## SOUTH TEES DEVELOPMENT CORPORATION

## **NET ZERO TEESSIDE DEVELOPMENT CONSENT ORDER**

# **RESPONSE TO COMMENTS ON RELEVANT REPRESENTATION**

OPTION 1 (1A - NATIONAL GRID, 1B - TRAFIGURA)  
Scale:1:25,000

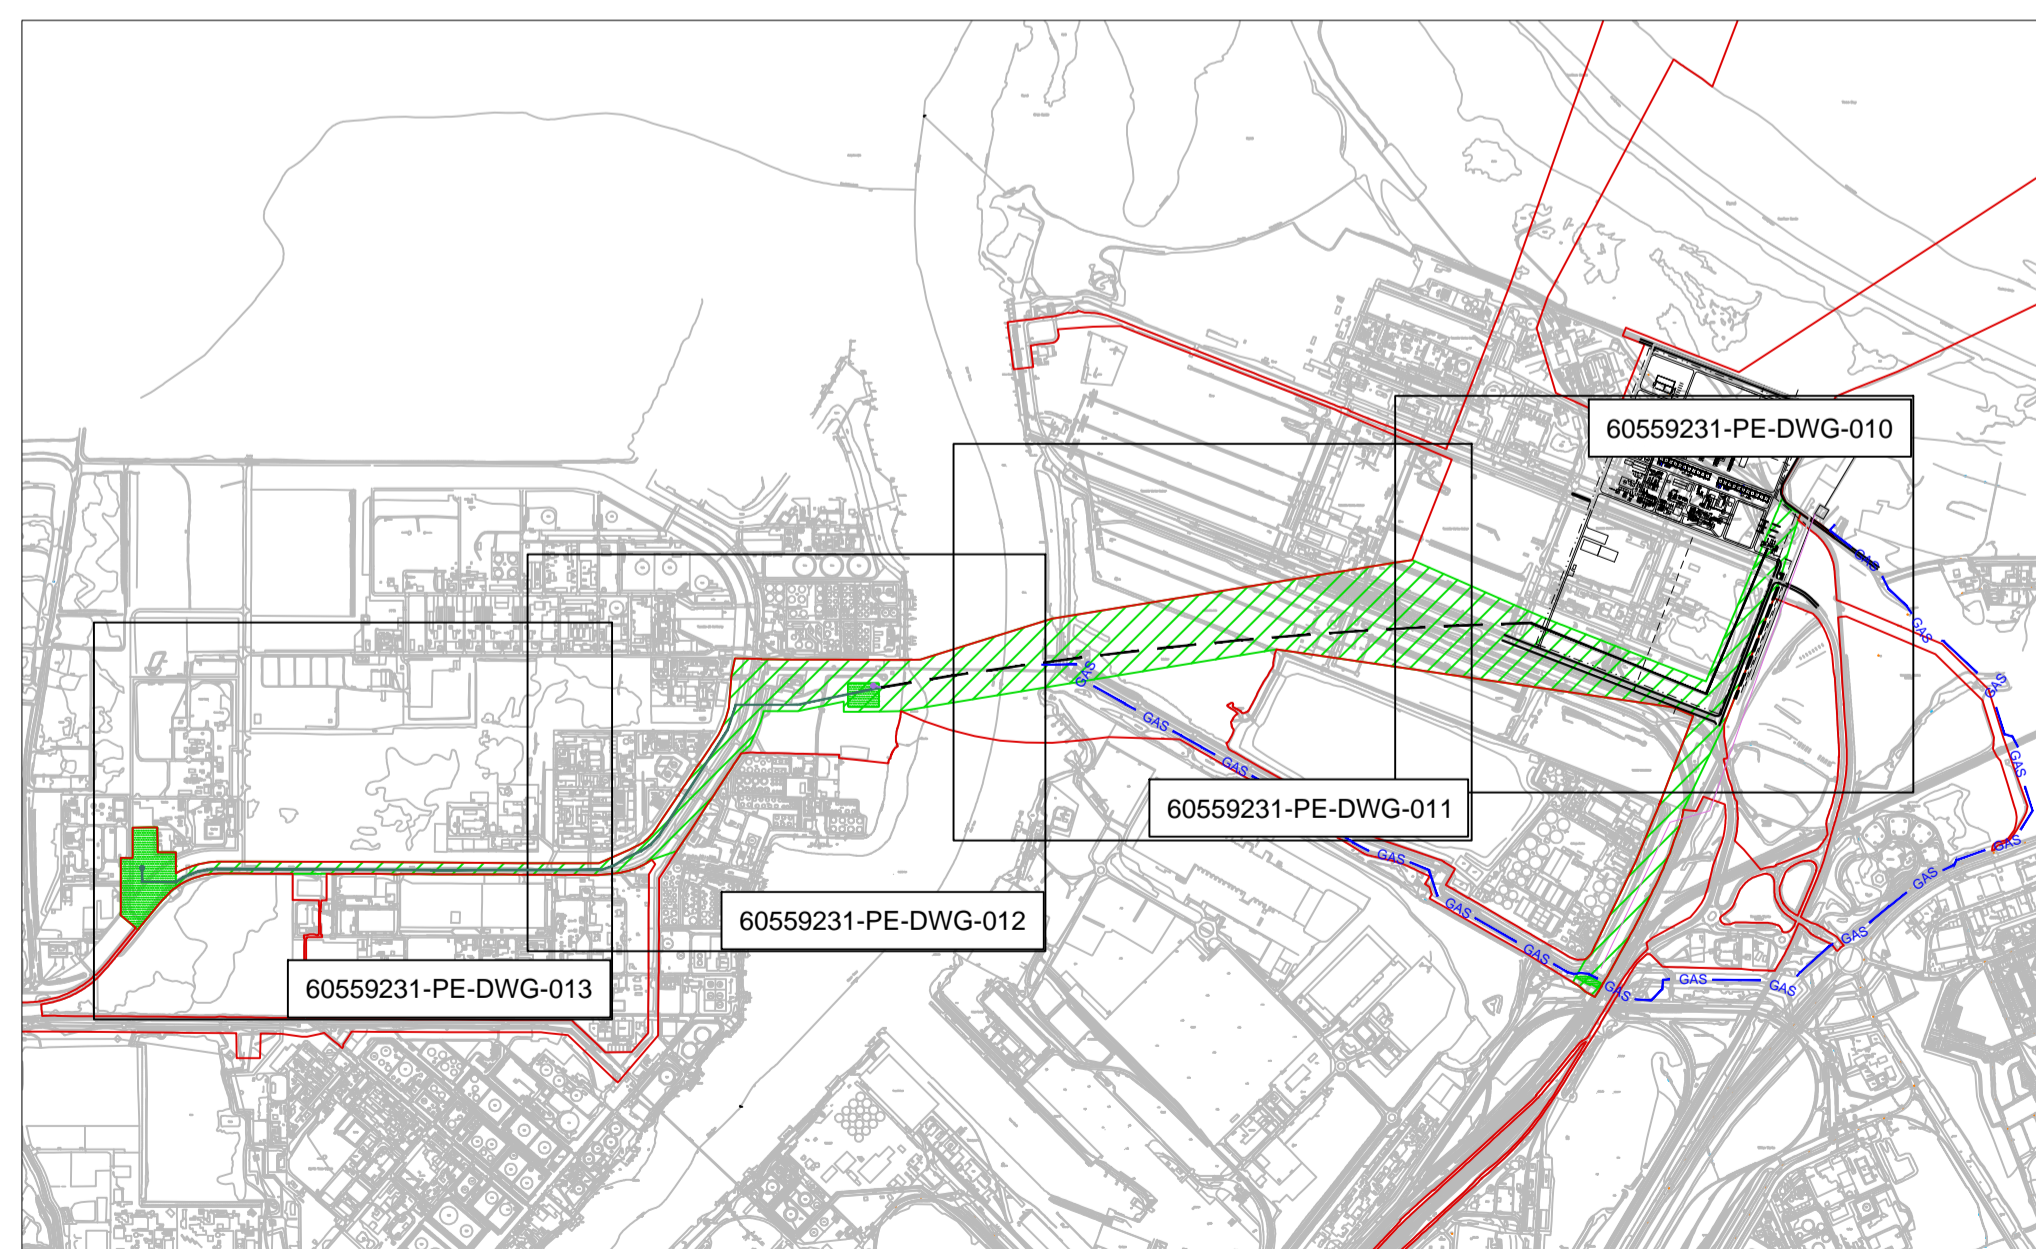
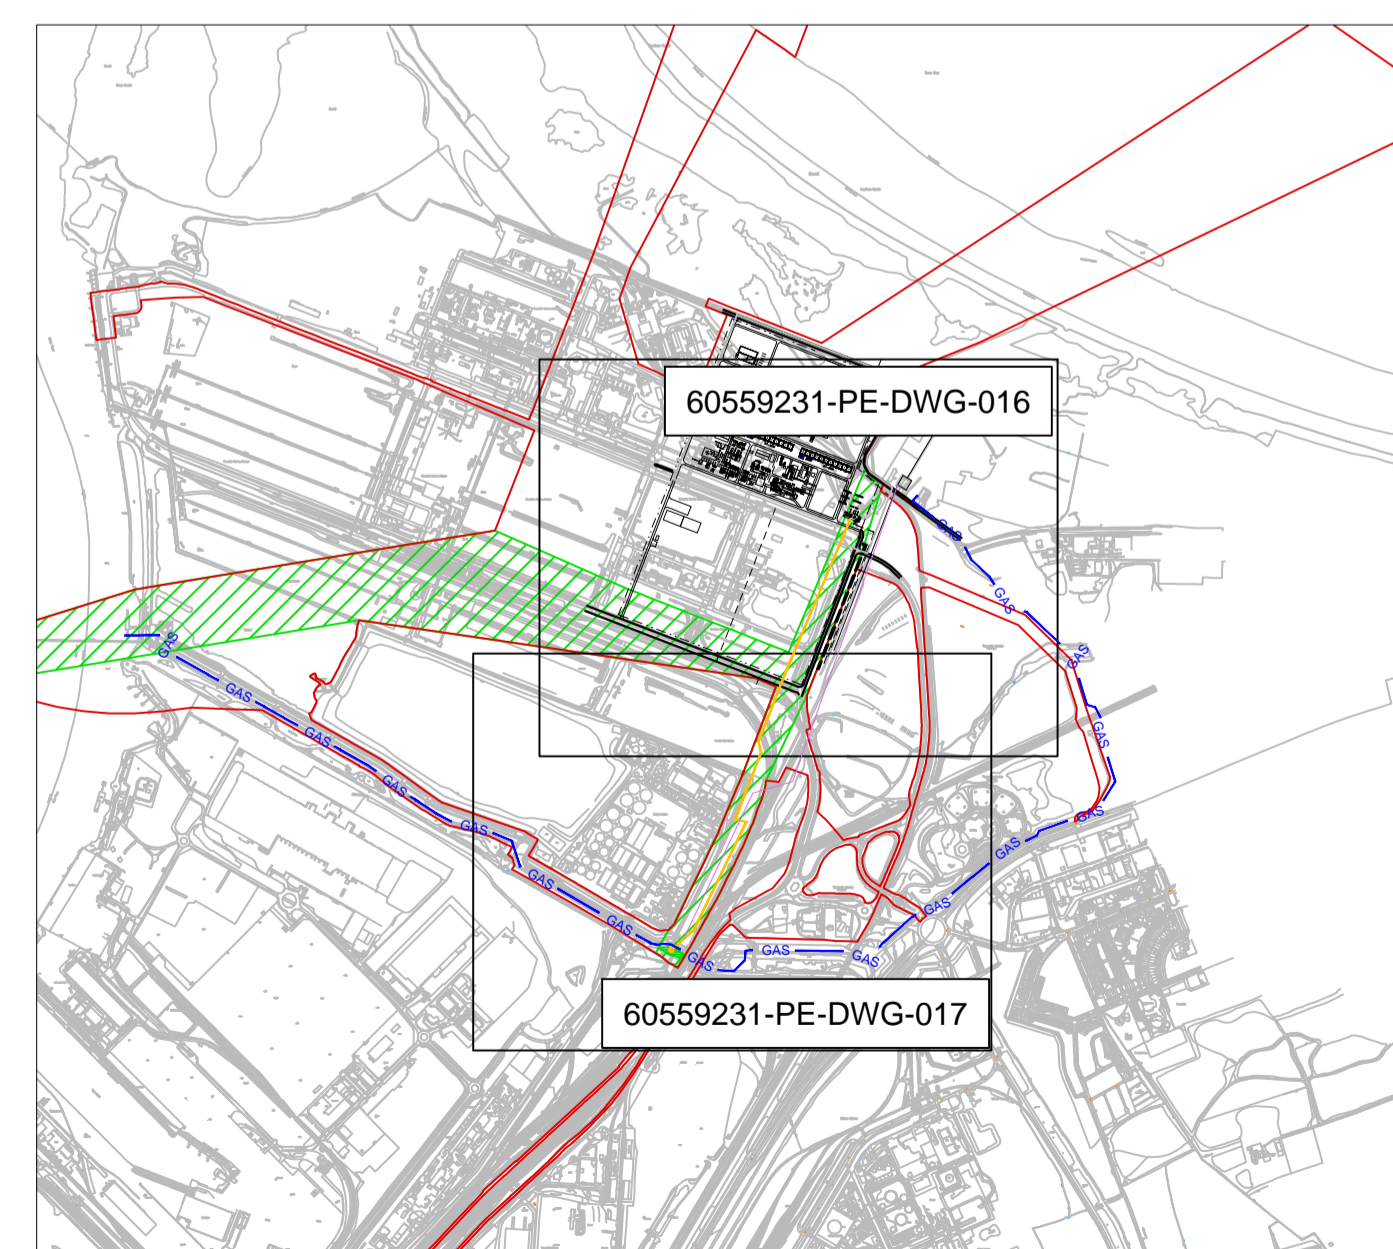
- 4.6 The NZT DCO currently contains two options for its natural gas connection. STDC objects to the first option which runs beneath and risks sterilising STDC land. There is a clear reasonable alternative to seeking compulsory powers over STDC's land for this pipeline, given the established Sembcorp utility corridor (a route that is indeed also being considered as one option for the CO2 Gathering pipeline route). STDC received verbal assurances from NZT's project team that the Teesworks option would not be included within the DCO for either the natural gas or CO2 gathering pipelines, owing the existence of the Sembcorp route. It is not clear why this level of flexibility has been included within the DCO when an alternative route exists that has less impact on STDC, and on the basis of previous discussions, seems to be the preferred route.
